CITY OF MERCER ISLAND

January 23, 2018

RE: ADU17-003, CAO17-005, SHL17-007, SUB17-004 Second Review Letter
Land Use Applications for proposed home, ADU, driveway and retaining wall construction within
a steep slope along the shoreline for the Lady Bug Trust.

CONCEPTUAL GRADING AND UTILITY PLAN
WITH CRITICAL SLOPES

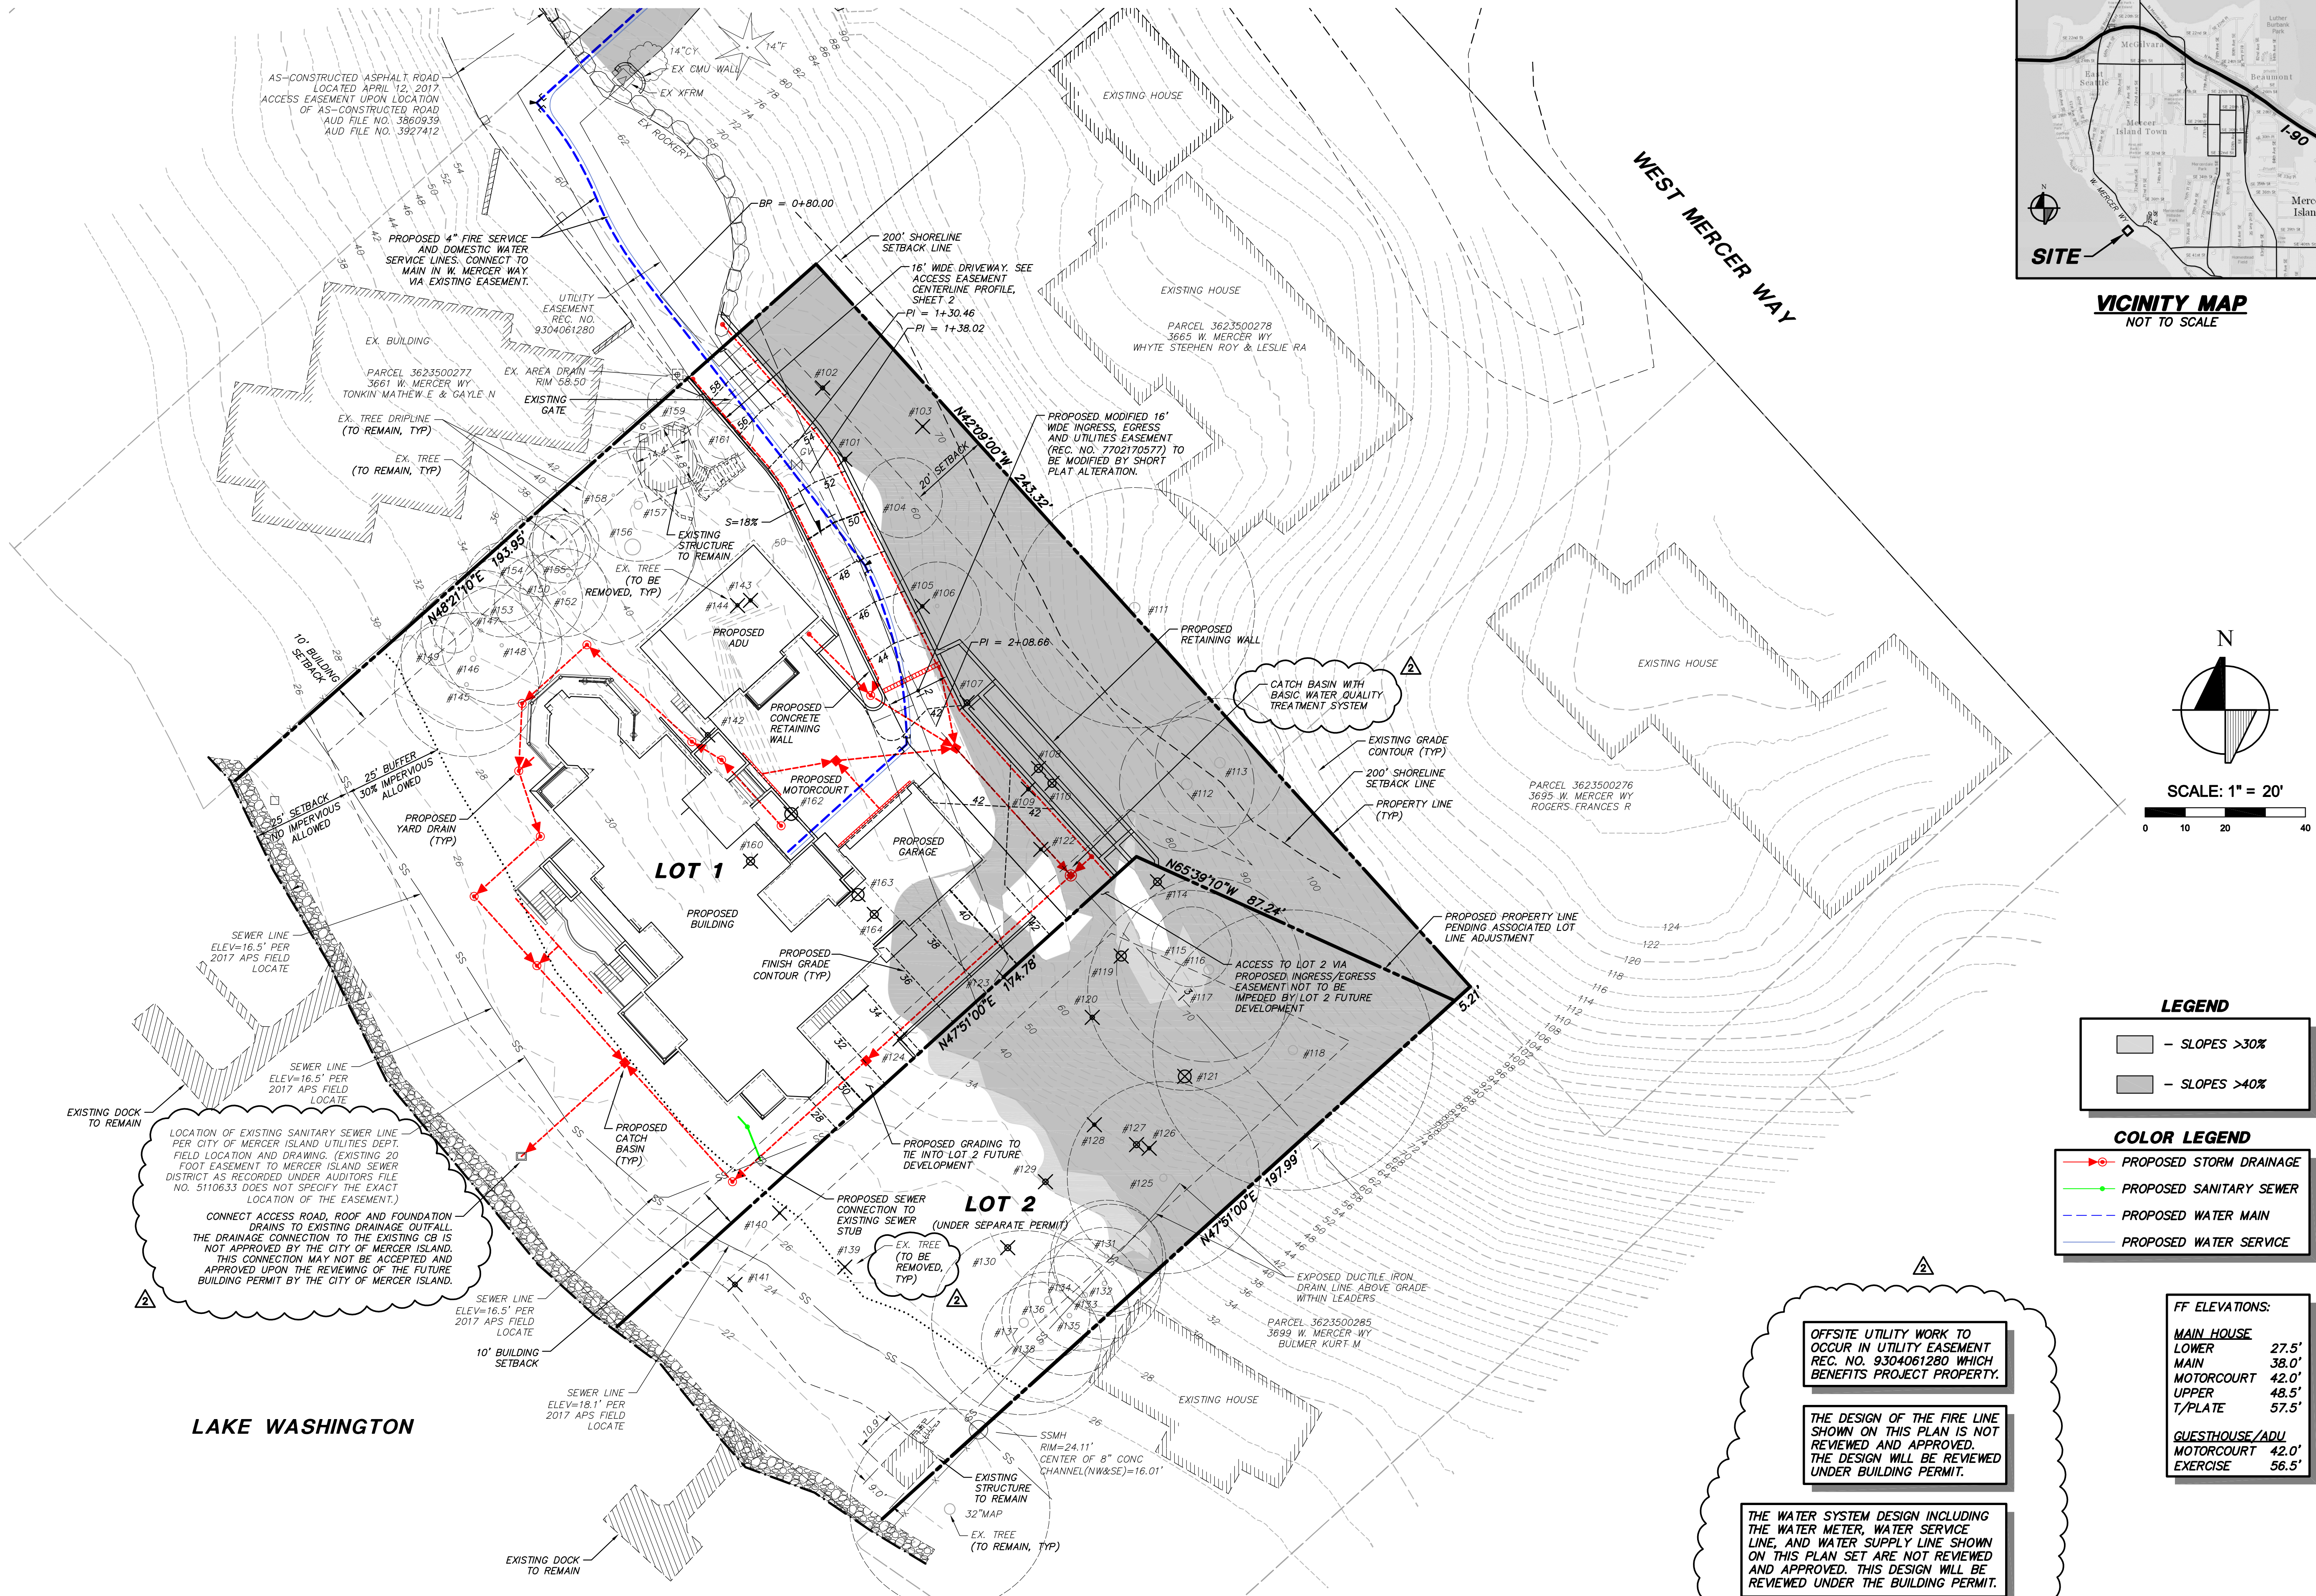
9. Please show edge of pavement and topography on sheet C3 in the area of the turn.
10. Please provide a preliminary code alternate related to the preliminary Fire Plan Review. Refer to the attached Code Alternate Information Sheet (Attachment A) and the Preliminary Fire Review Sheet (Attachment B).
